Planning Application Ref: AB/9/14/TC

Location : Garden r/o 6 Bakers Hill Road, Arundel

Description of works: *This seems to be linked to a Planning Application*

Site Plan Trees
Scale 1:100

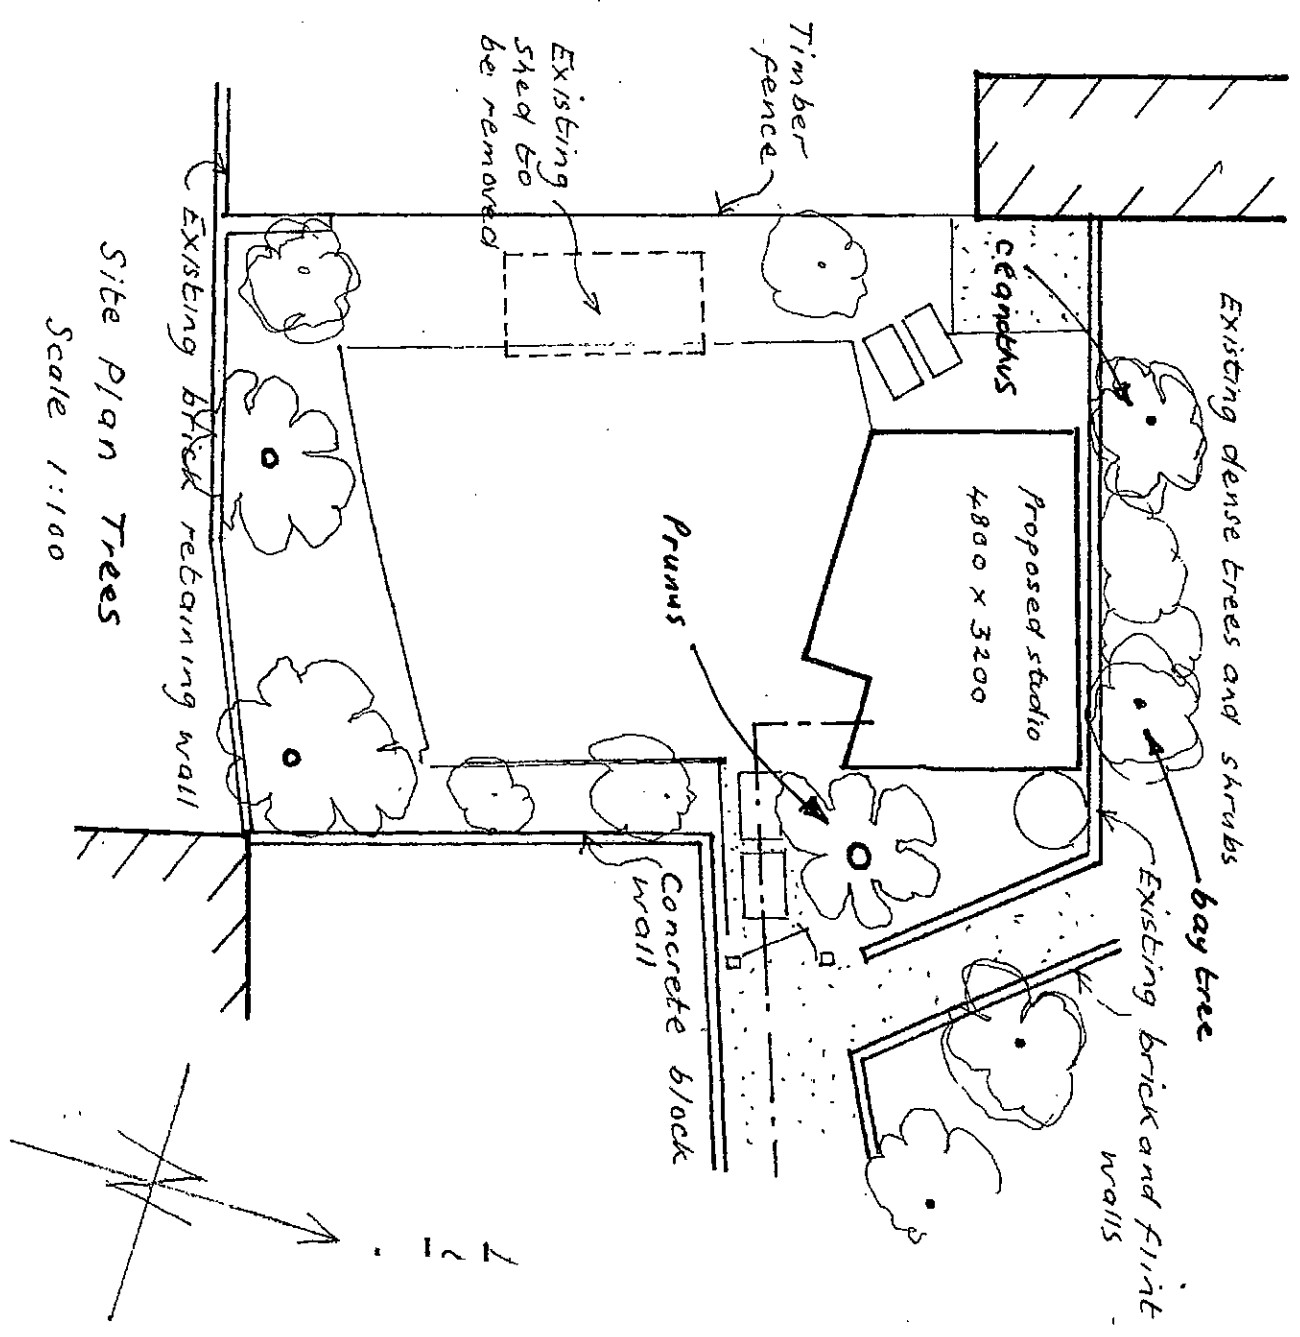
Flowering Cherry – *Prunus avium* – to remove some branches overhanging adjoining garden in Bakers Hill – but no specific dimensions or indication of which branches is provided.

Ceanothus & Bay Laurel – to cut back both plants which overhang the boundary wall and grow into the garden from the neighbouring property.

- Both plants are growing in the neighbours garden to the north side of the boundary wall but most of their crowns are presented overhanging the boundary line into the garden of No6.
- Some stems are resting on the top of the wall causing it to crack and in the case of the Bay the expansion of the stems is cracking the boundary wall – not sure who owns it?
- All of these plants are close to flowering - which is a very stressful time for them and when most damage can be done [entry of fungal and viral problems into the vascular system] so this is perhaps the worst time to prune them and I suggest that if approval is given there is a strong recommendation made that no pruning takes place until the plants have finished flowering.

- The owner has not been specific with her request so it is not possible to determine this notification until a site meeting has been arranged to discuss and agree the extent of works – some pruning would be acceptable but an excess could easily ruin this trees amenity value!

- To control the level of pruning we would have to make a TPO and these trees do not meet the criteria we have to apply in assessing amenity value.
- However, I will require more information or a site meeting in order to properly resolve this notification.
